DOC21/825860-10

EPA Advice on Environmental Impact Statement

I refer to your request for advice requesting a review by the NSW Environment Protection Authority (EPA) of the Environmental Impact Statement (EIS) for the proposed Padstow Resource Recovery Facility (Application SSD-10450) (Proposal) at Lot A DP103140 also known as 81 Gow Street, Padstow NSW 2211(Premises).

NSW Environment Protection Authority (EPA) Submission on Environmental Impact Statement (EIS) for proposed Padstow Resource Recovery Facility (Application SSD-10450) at 81 Gow Street, Padstow NSW 2211

Figure 3-1: Site Water Balance Diagram

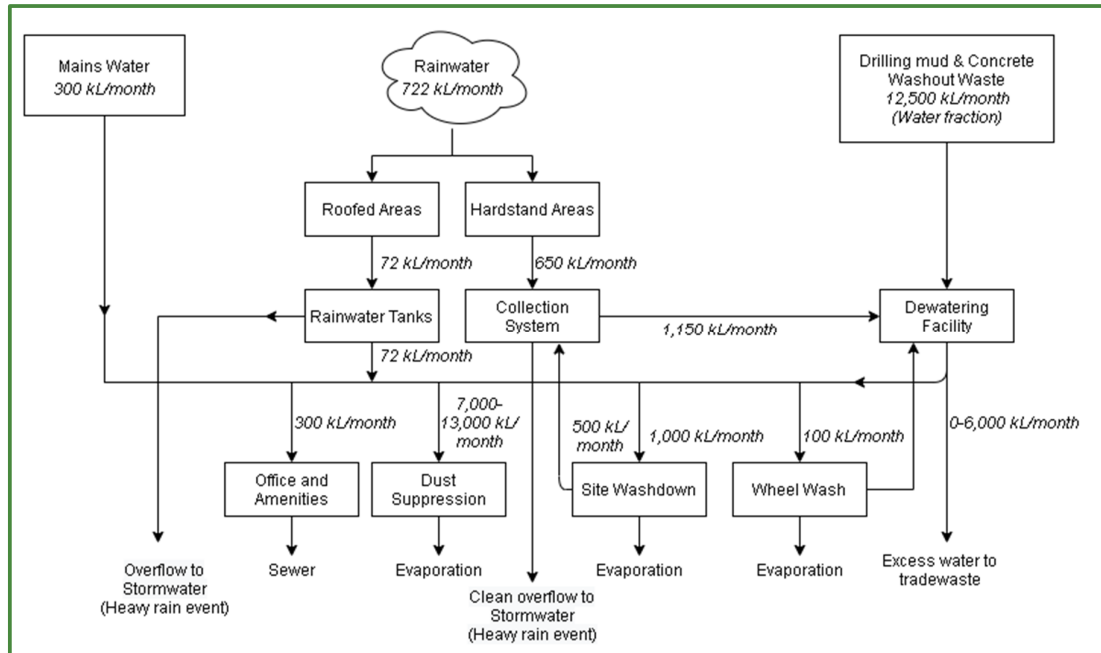
- Noting that Figure 3-1 indicates that the monthly site rainfall volume is 722kL, the proposed reuse rate (13,000kL/month) is not possible unless mostly comprised of effluent from the dewatering facility.

- Reuse at the assumed rate would result in substantial pooling and runoff.
- Figure 3-1 of the EIS appears to assume that up to 13.6ML of water would be lost to evaporation per month (dust suppression + site washdown + wheel wash).

- This equates to approximately 44mm/day across the entire site and appears much higher than would be expected based on typical evaporation rates.
 - For comparison, at the nearest Bureau of Meteorology weather station with evaporation data (Prospect Reservoir), mean evaporation ranges from 1.6mm/day in June to 5.6mm/day in December.

The EPA recommends that the response to submissions (RtS) includes a daily time-step water balance.

It is recommended the daily time-step water balance be based on:

- rainfall data,
- temporally variable water reuse rates (seasonal and weather dependant), and
- seasonal evaporation rates.
